19 July 2019

Ms Aditi Coomar
NSW Department of Planning, Industry and Environment
GPO Box 39
Sydney NSW 2000

RE: Sydney Football Stadium (Stage Two Design, Construction and Operation) – 40-44 Driver Avenue, Moore Park (SSD-9835)

1 WALL TYPE 1 - PRECAST CONCRETE WALL WITH INTEGRATED TIMBER BENCH
NTS PERSPECTIVE

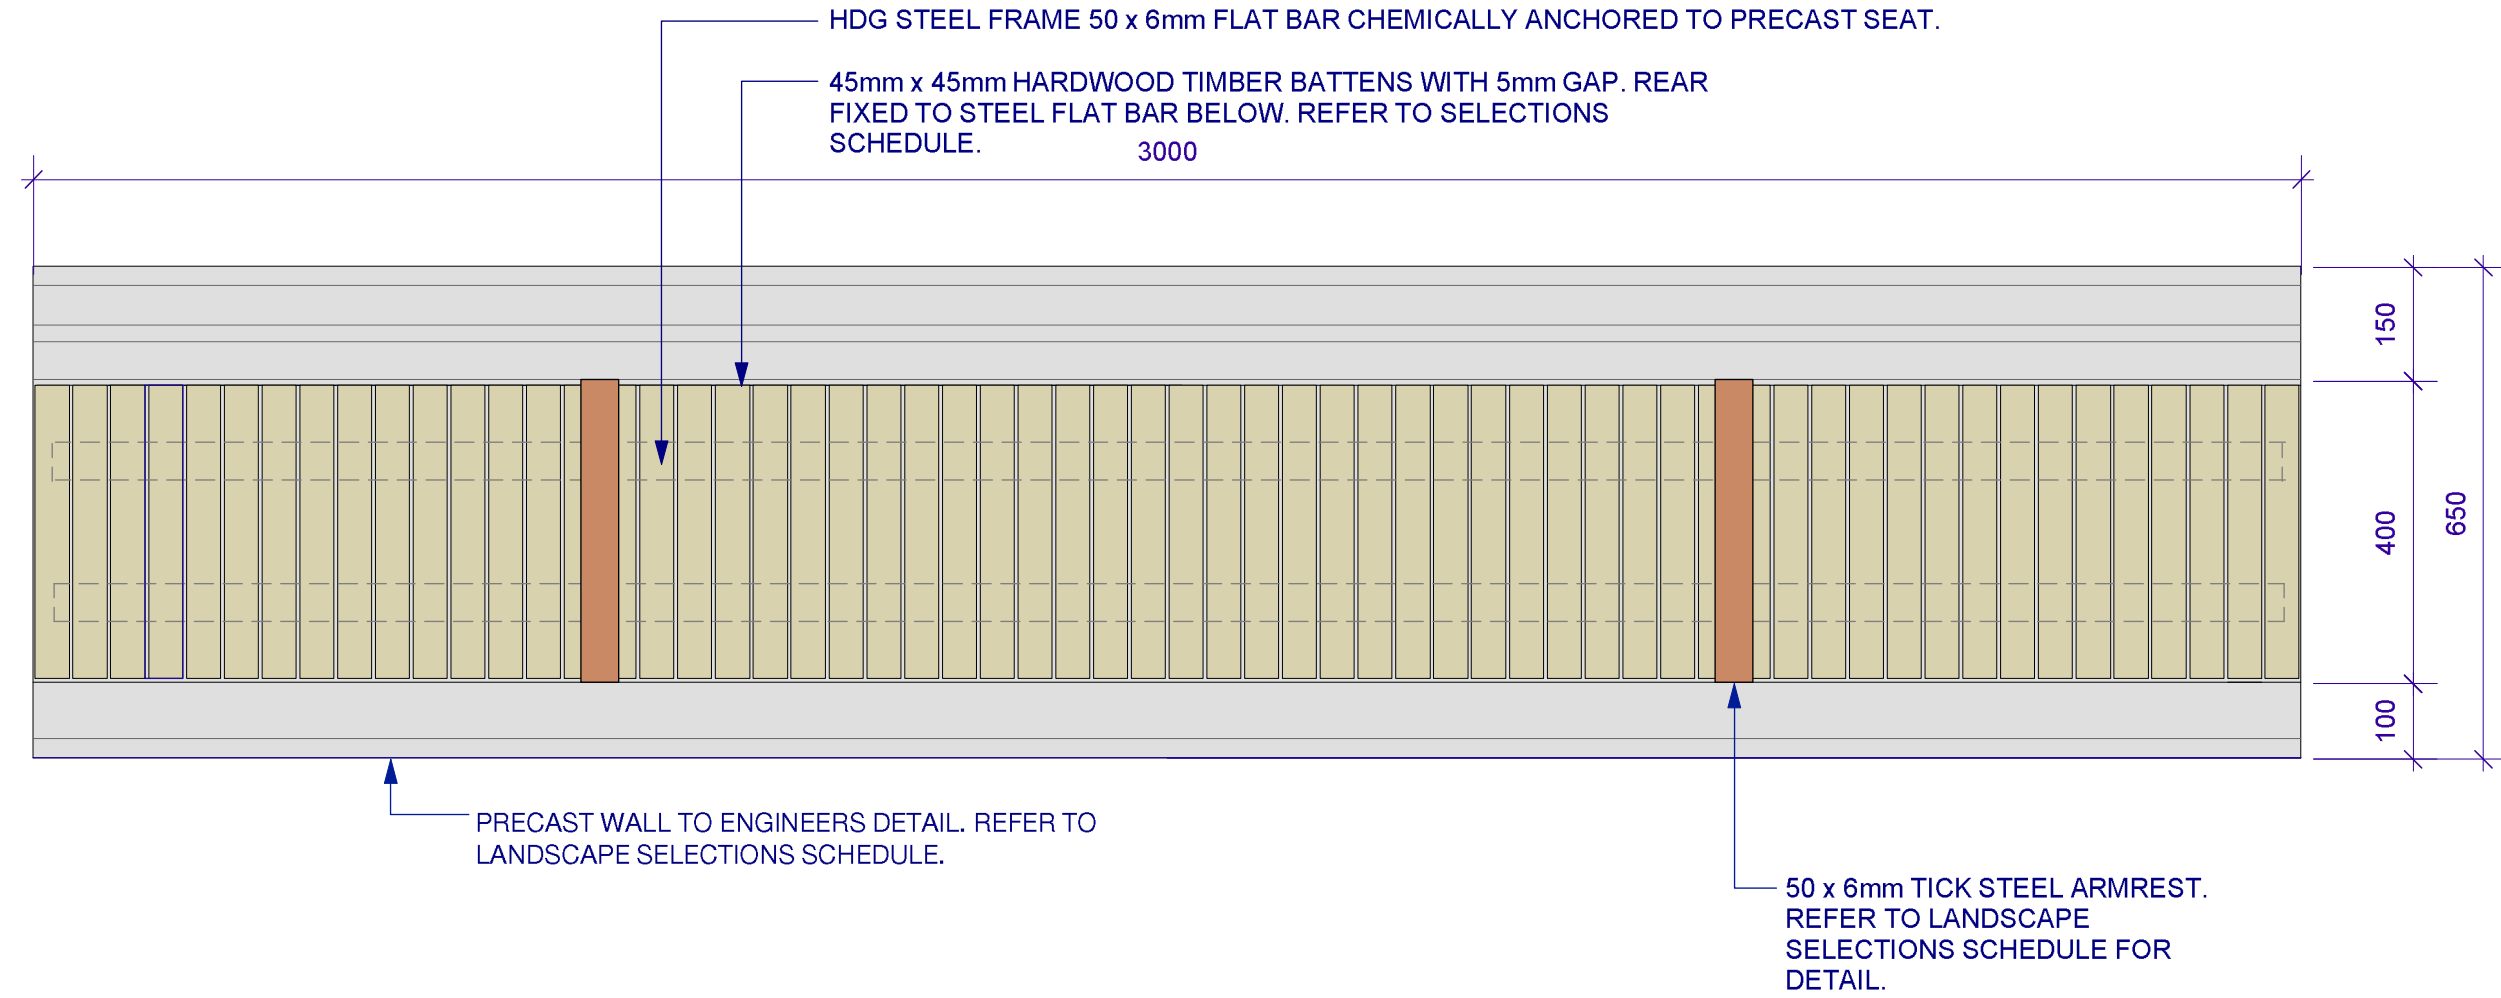
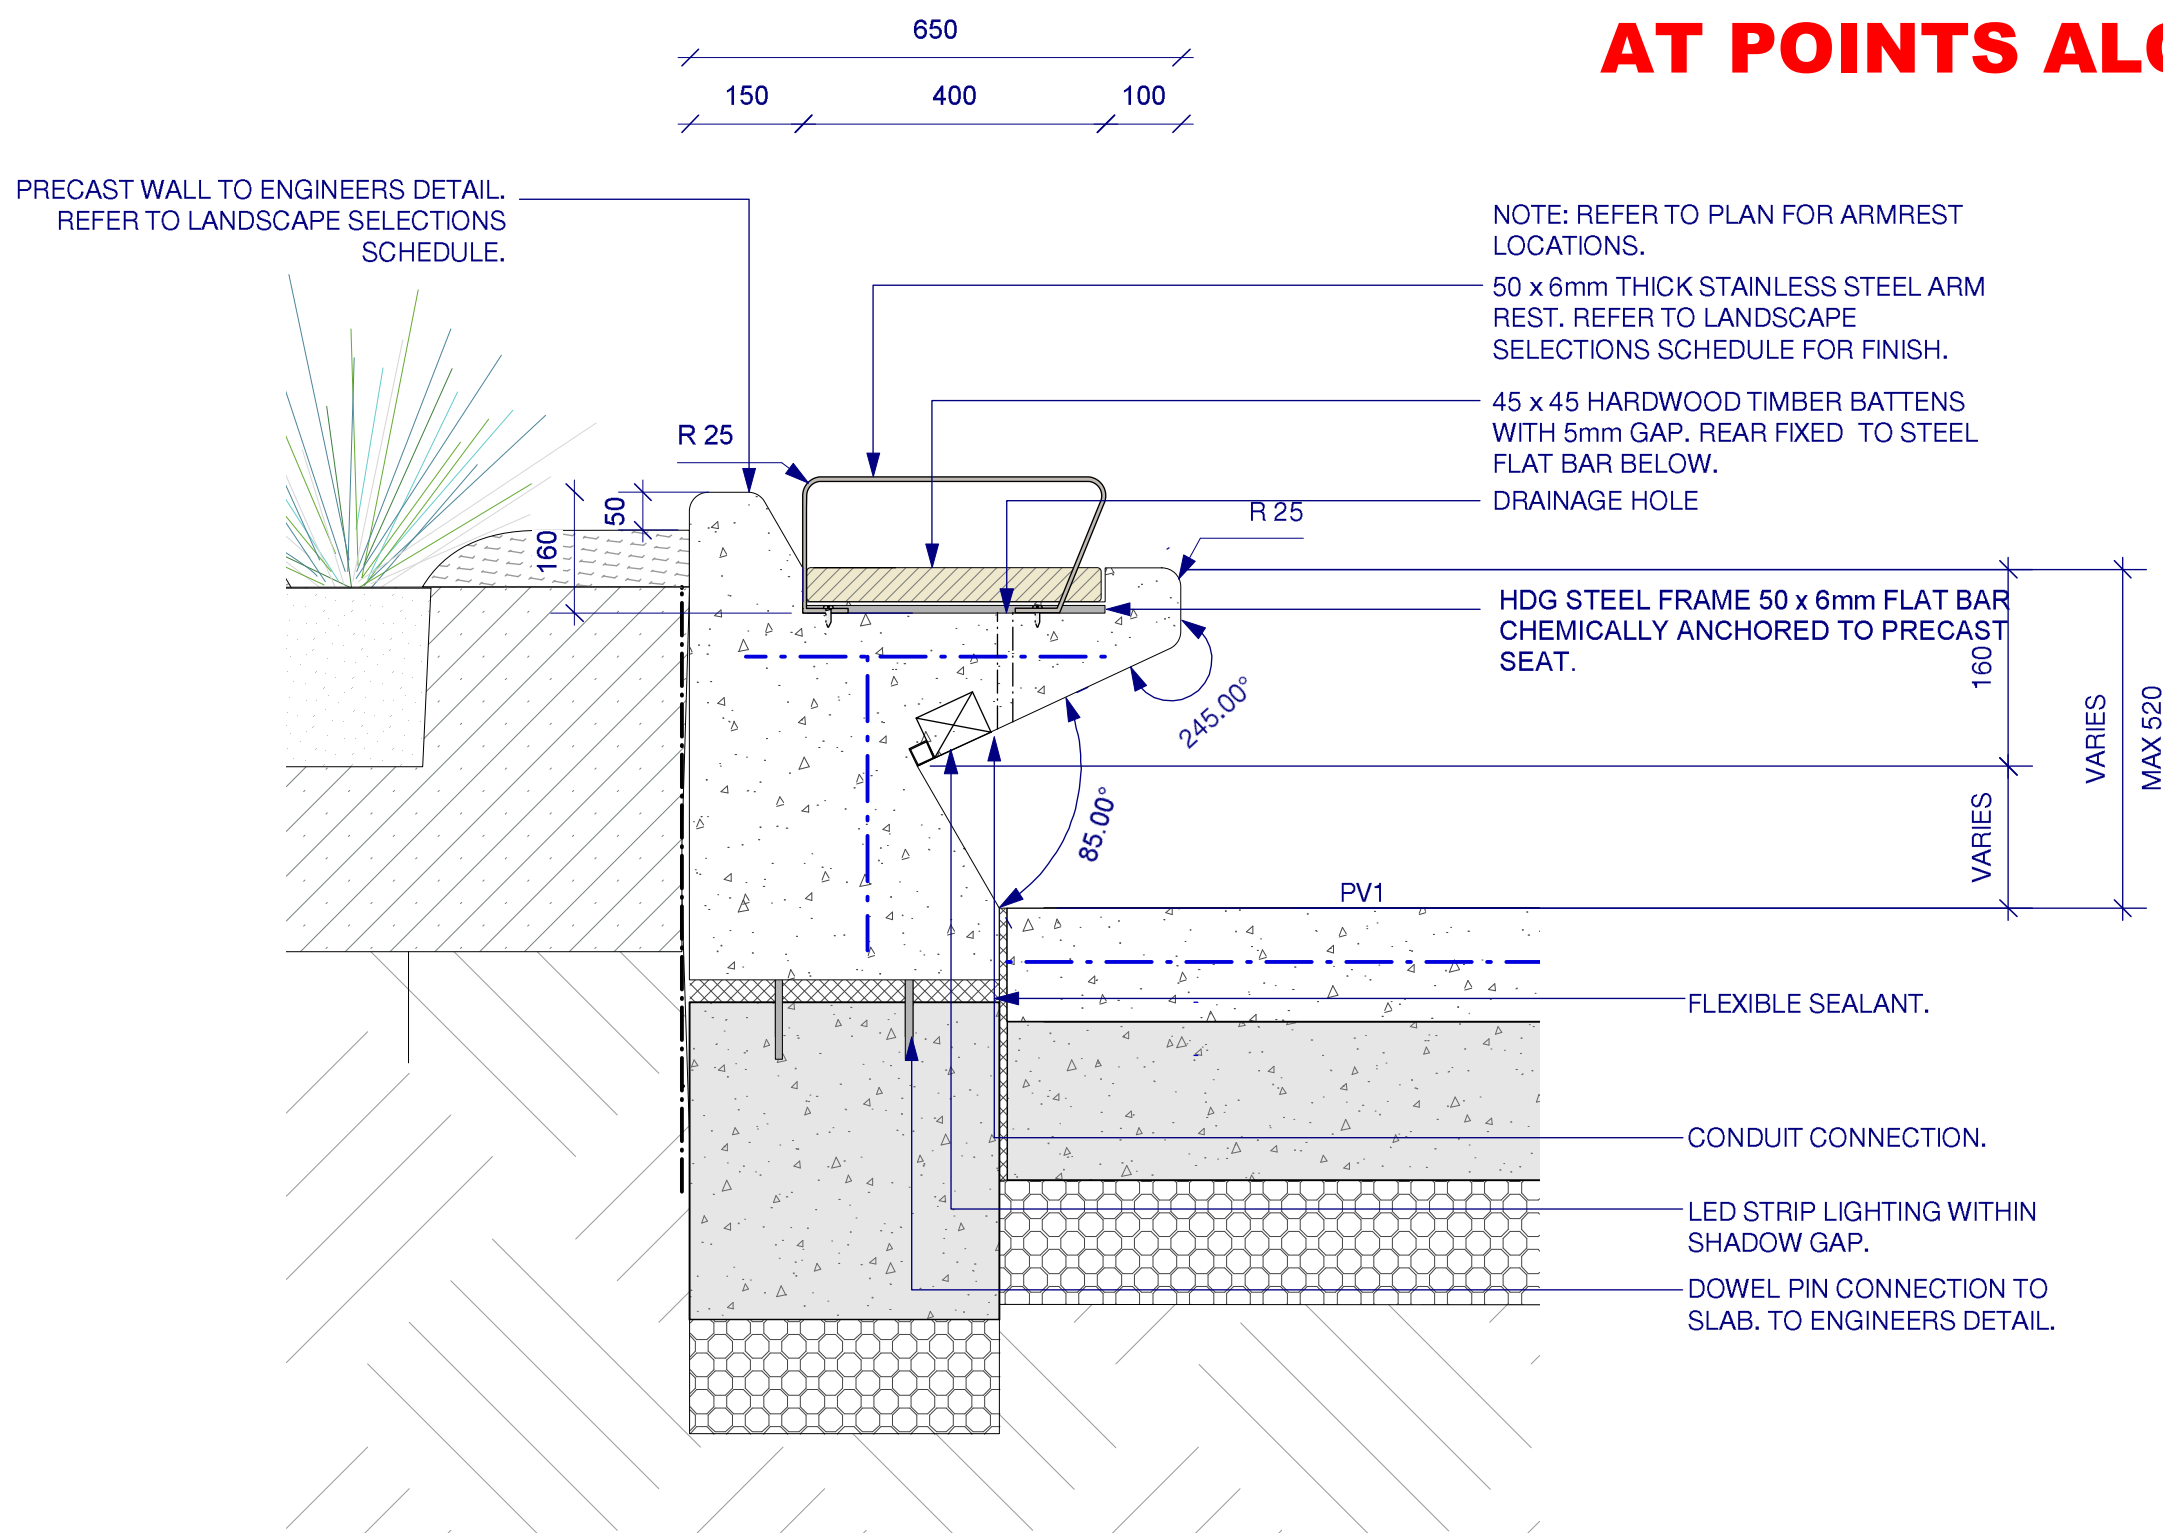
- Council is supportive of the proposed robust and sustainable public domain materials.
- Pedestrian, user amenity and seating must consider the amenity for persons with physical challenges and cultural diversity.
- Consideration of counter terrorism mitigation measures should be incorporated in the stadium circulation and public domain design.
- Access appears to only consider issues of gradient. Consideration must be given for persons with other disabilities such as poor vision and hearing.
- Council supports the tree retention/replacement ratio as a minimum for the loss of trees as a consequence of stadium development.
